Historic England

WRITTEN REPRESENTATIONS

A63

Castle Street Improvement Scheme, Kingston Upon Hull

Earl de Grey Public House

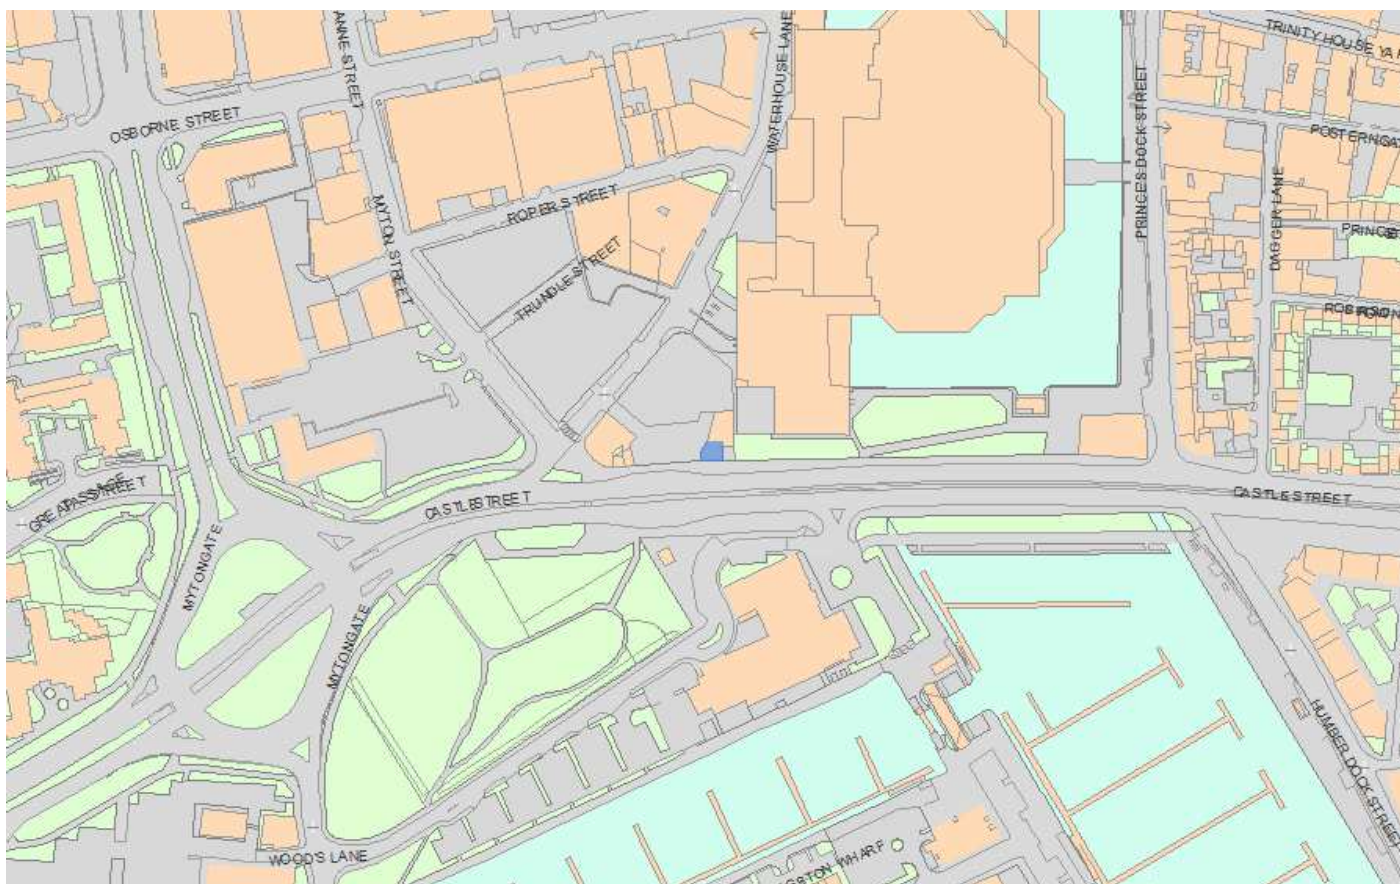
shopfront. HBMCE therefore disagrees with the 'medium value' ascribed to the Grade II Listed Earl de Grey Public House in para 8.9.17 (page 30) of the Cultural Heritage Assessment (Volume 6, Appendix 6.8 Cultural Heritage Assessment, A63 Castle Street Improvement, Hull).

3.3.4 The Scheme proposes the dismantling of the Grade II Listed Earl de Grey Public House. Work No.30 'Work to listed buildings – Castle Buildings and Earl de Grey; partial demolition of Earl de Grey and partially rebuilding approximately 3 metres to the north of existing position'. However, apart from archaeological recording (not specified) prior to and during the dismantling, no additional mitigation has been proposed (para 8.8.9 (page 27) of the Cultural Heritage Assessment (Volume 6, Appendix 6.8 Cultural Heritage Assessment, A63 Castle Street Improvement, Hull).

3.3.5 HBMCE considers the impact of dismantling of the Earl de Grey with no detailed scheme for its rebuilding would result in substantial harm to the significance of the Grade II Listed Building.

3.3.6 HMBCE considers that the minimum necessary requirement is that a detailed method statement should be provided for the taking down and rebuilding of this listed building. A detailed method statement should also be provided for the moving of the faience shopfront. A timetable for the rebuilding should also be agreed with Historic England and Hull City Council.

# Castle Buildings

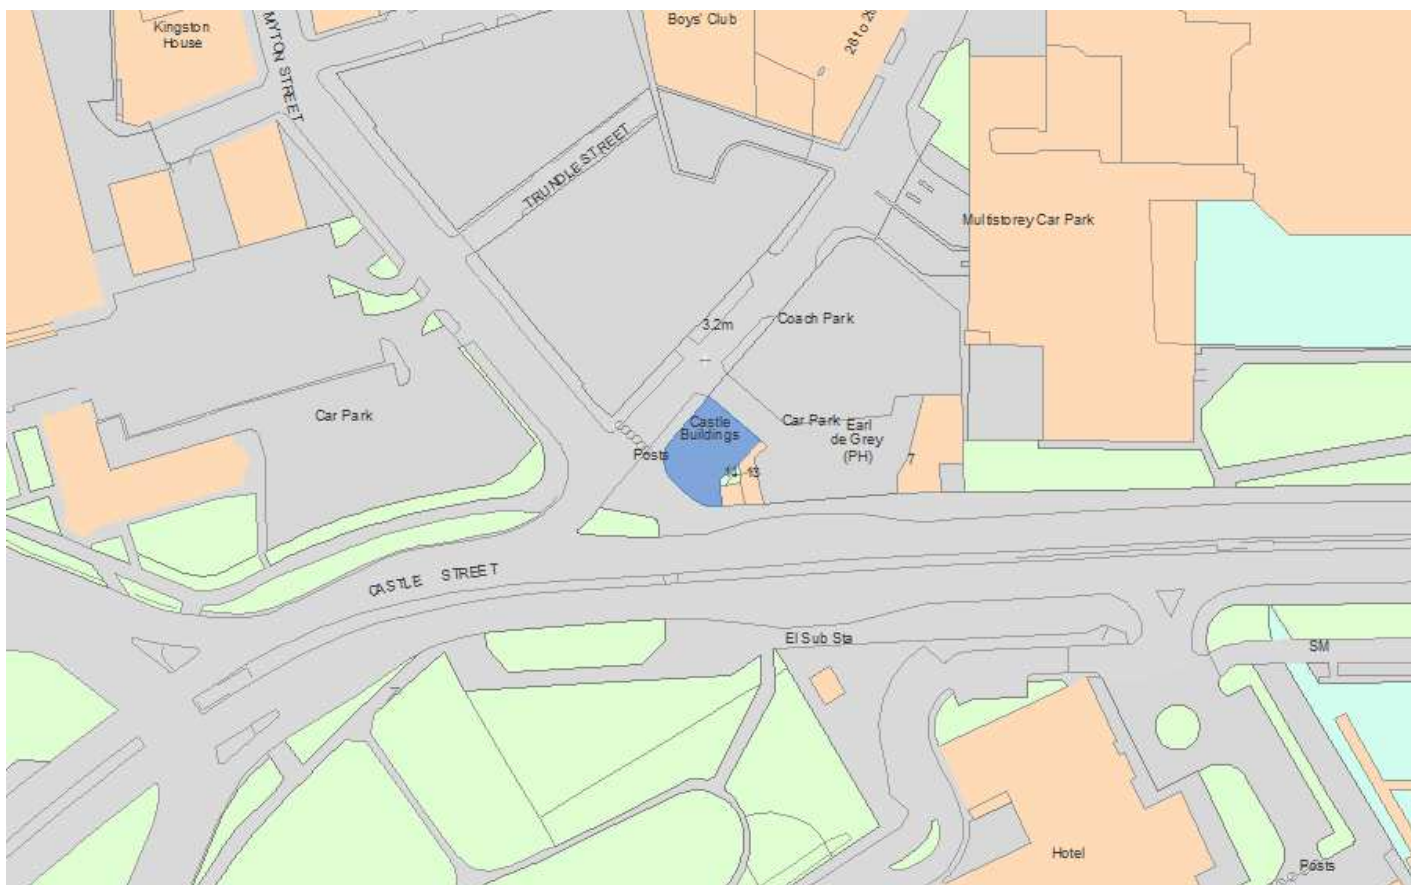
clarified whether any further demolition of this Grade II Listed Building is required for the purposes of the Scheme.

- 3.4.5 We consider the Castle Buildings 'high value' by virtue of its considerable special architectural and historic interest deriving from its architectural character, landmark qualities and the remarkable survival of its original interior. HBMCE disagrees with the 'medium value' ascribed to the Grade II Listed Castle Buildings in para 8.9.16 (page 30) of the Cultural Heritage Assessment (Volume 6, Appendix 6.8 Cultural Heritage Assessment, A63 Castle Street Improvement, Hull).

- 3.4.6 The Scheme proposes the partial demolition of the Castle Buildings. However, it is unclear how much of the Listed Building and which parts are proposed for demolition or the manner in which the retained portions are to be identified and secured during the demolition phase in order to protect the Listed Building.
